CLIENT:
Site Plan
3120 Mount Herman Road
Monument, CO
80132

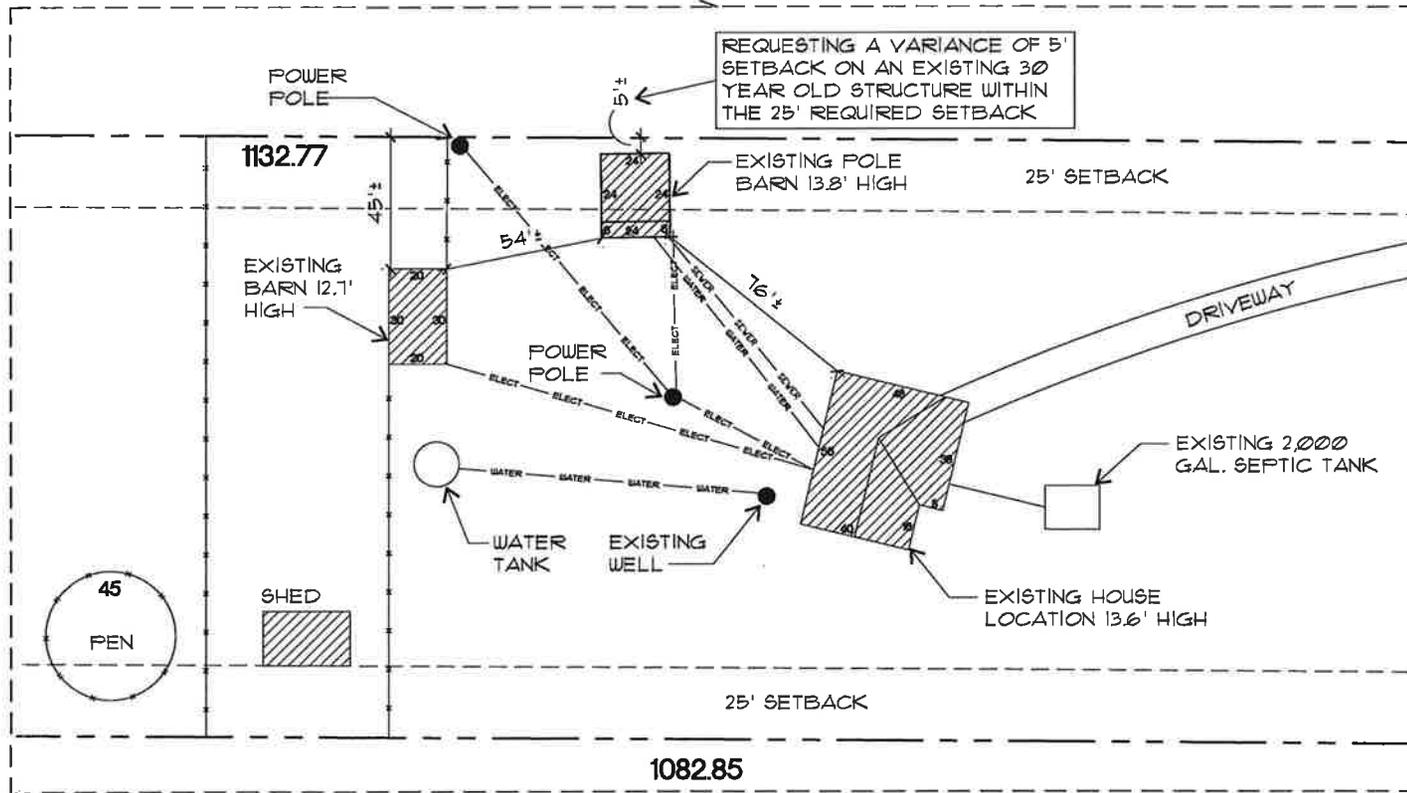
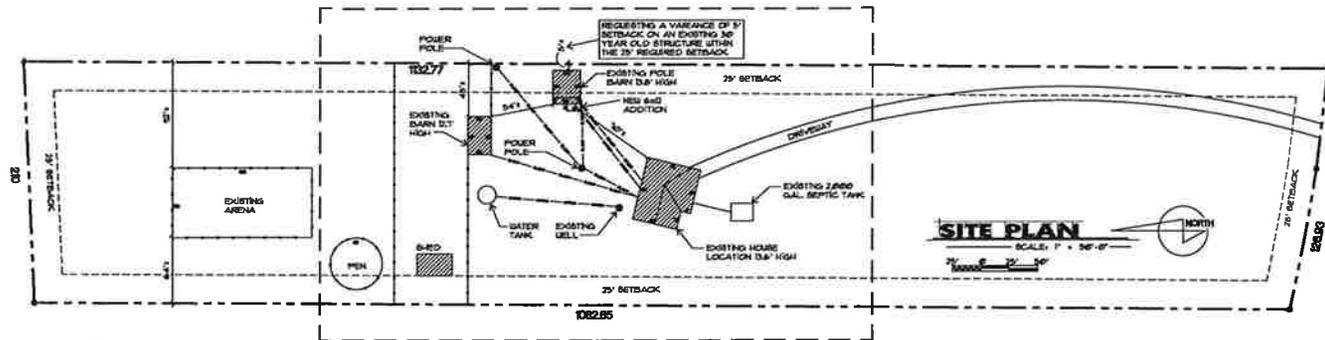
Please provide a formal site map with a larger scale, and ensure that all notes and the legend on the site map are clearly visible.

Please include:
- PCD File No: BOA242

Please include:

- Applicant Name
- Address of project site
- Property tax schedule number: 7122001010
- Legal Description: TRACT 3 PANORAMIC ACRES
- Lot/parcel size: 5.34 acres
- A note about the type of variance you are requesting: "A side setback of 5 feet where 25 is required"

Also, in addition to this site plan, which shows the entire property, please also include a "zoomed in" version within the extents shown in green here so that the Board can see more details of the area of interest and get a clearer idea of what you are requesting. On the zoomed in version, please include dimensions of the buildings including height.
